# PONDEROSA AT LORSON RANCH FILING 3

## A PLANNED UNIT DEVELOPMENT AND PRELIMINARY PLAN

REV #	REVISIONS	DATE
1	1st Response to County Comments	1.8.2020
2		
3		
4		
5		
6

TRACTS &  
 OPEN SPACE  
**P2** of 10

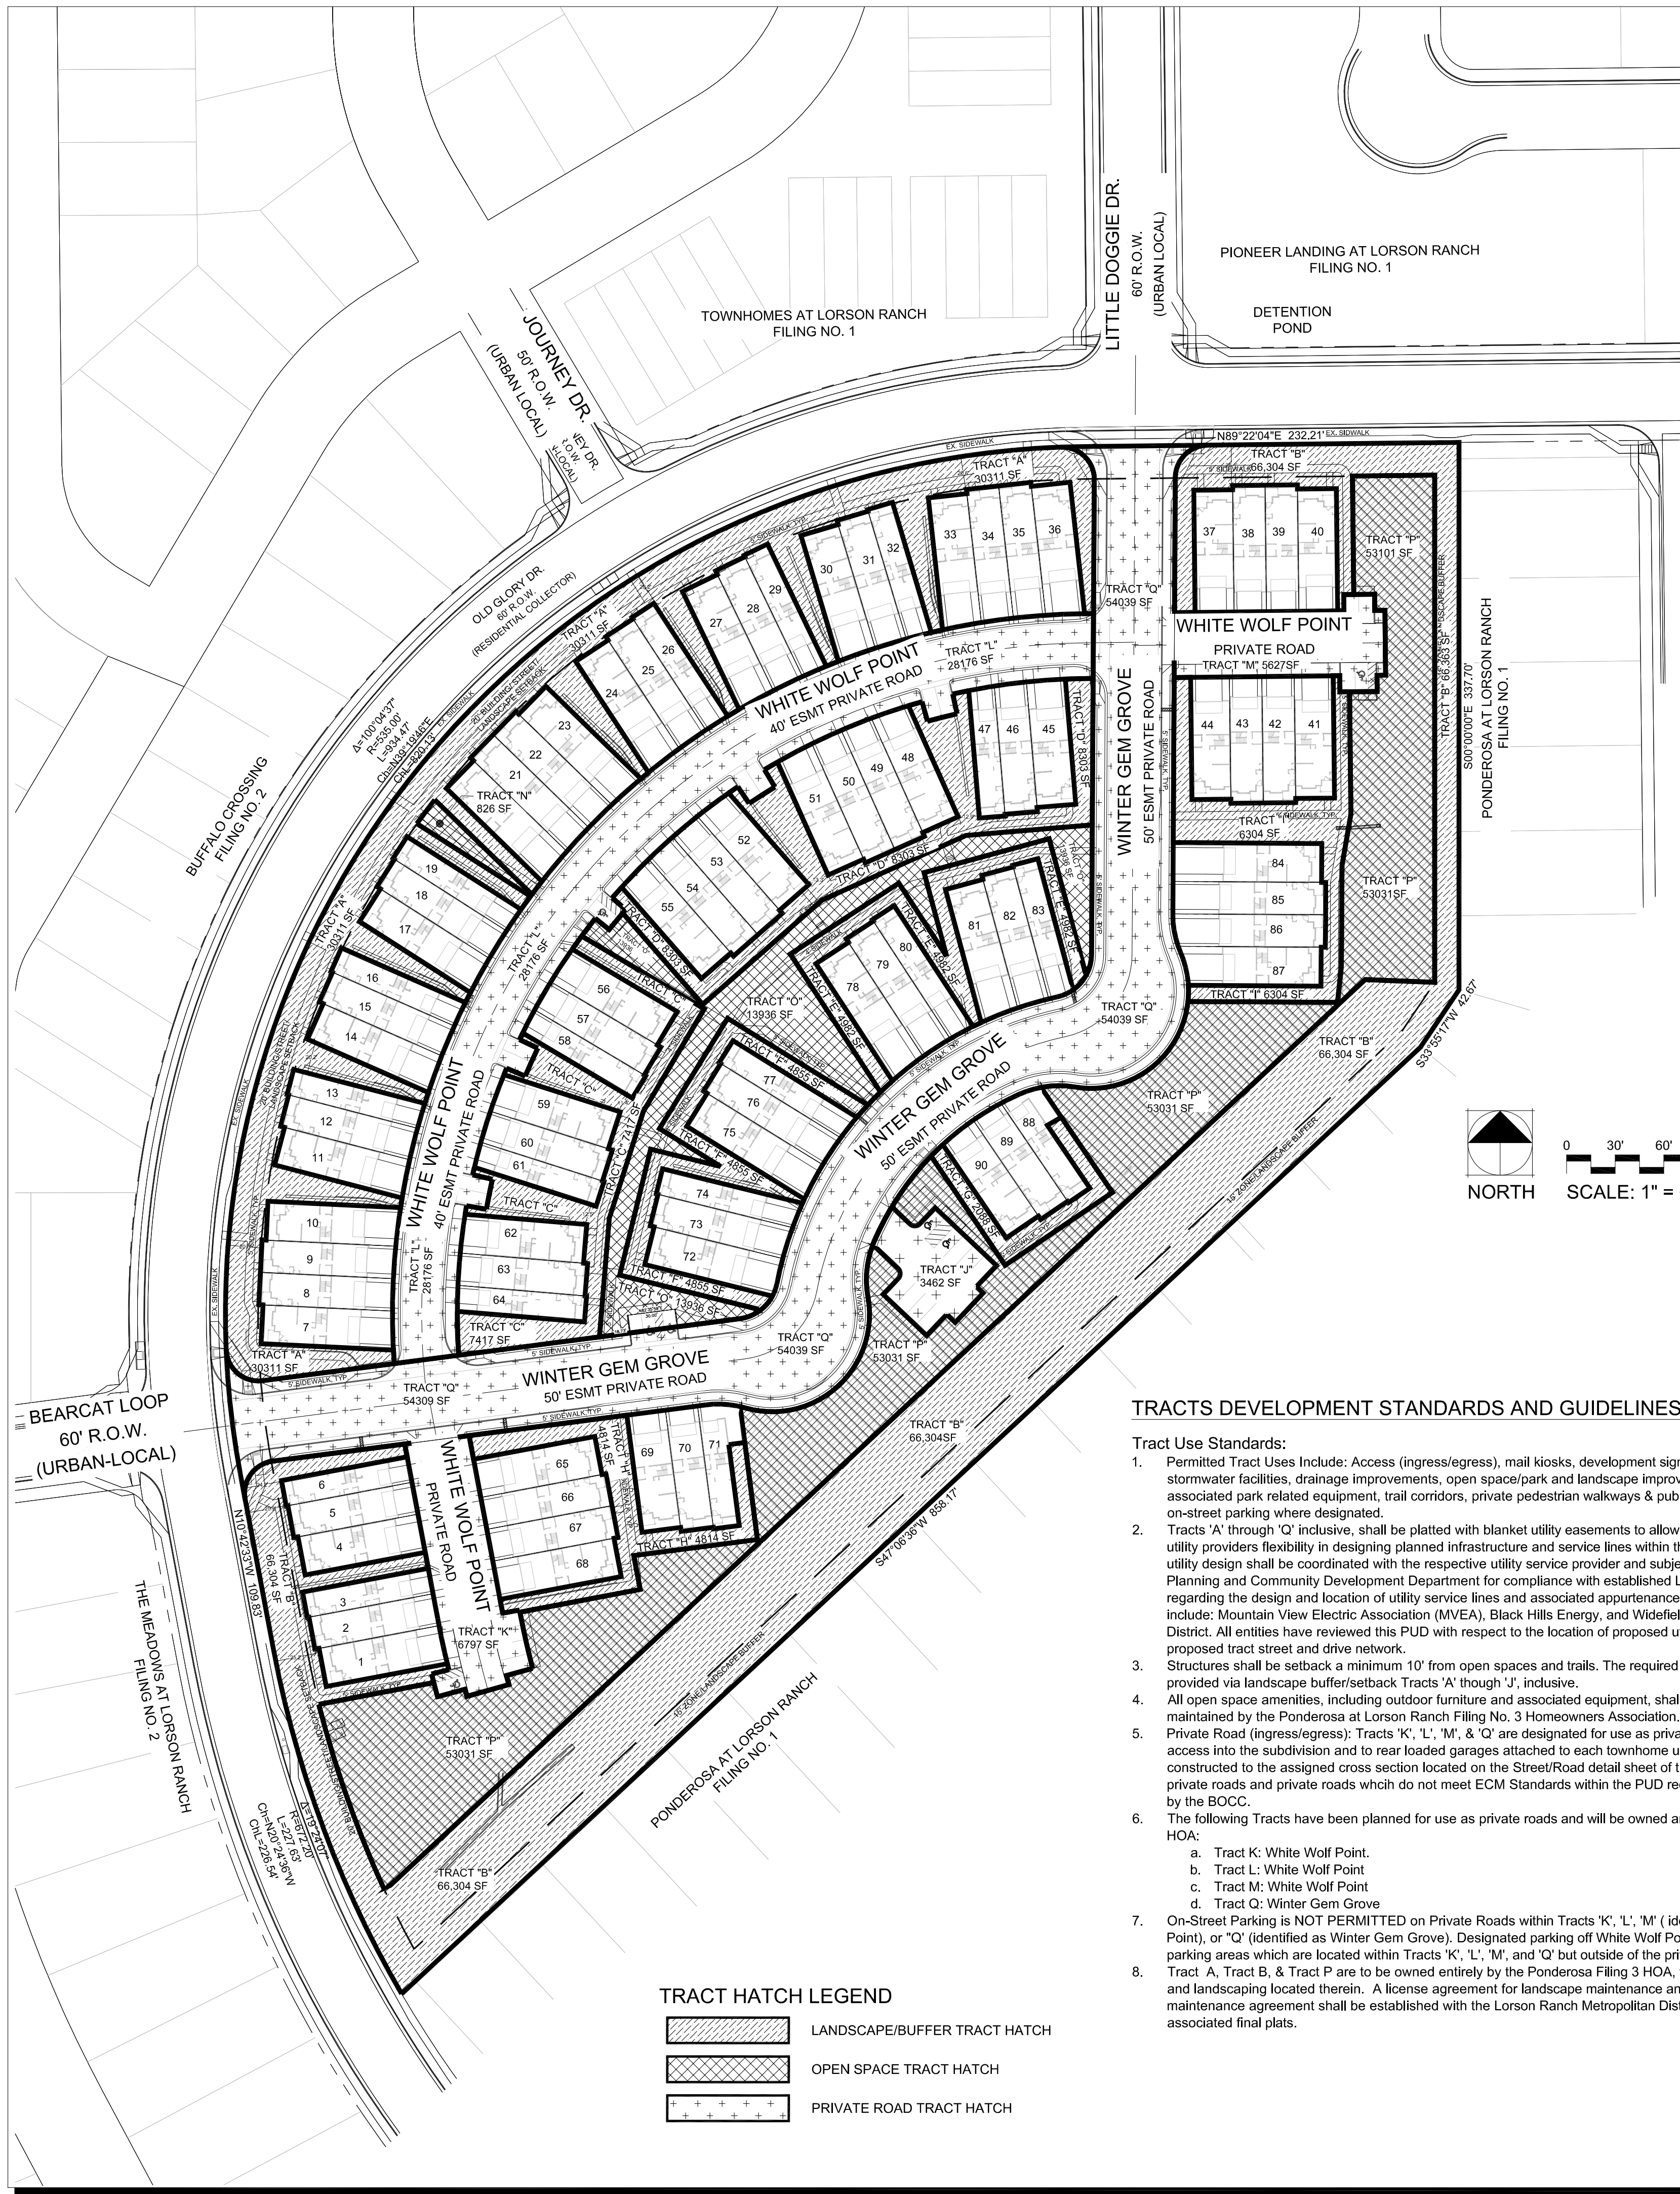
CHANGES SHOULD BE REFLECTED IN LOI  
SEE COMMENTS BELOW...

should these be LRMD?

Place some dimensions from lots to public roads- there should be setbacks from structures from perimeter of development incorporated into page 1 dev staddrs.

OLD GLORY STREET LINES SHOULD BE OWNED AND MAINTAINED BY DISTRICT  
IT WOULD SEEM LIKEEY THAT THE OVERALL DEVELOPMENT FOR LORSON WILL USE PLAY GROUND-SHOULD THE DISTRICT BE OWNER AND MAINTENANCE PROVIDER  
HOA HAS LARGE MAINTENANCE EXPENSES IS THAT FEASIBLE AT TGIS PRICE POINT?
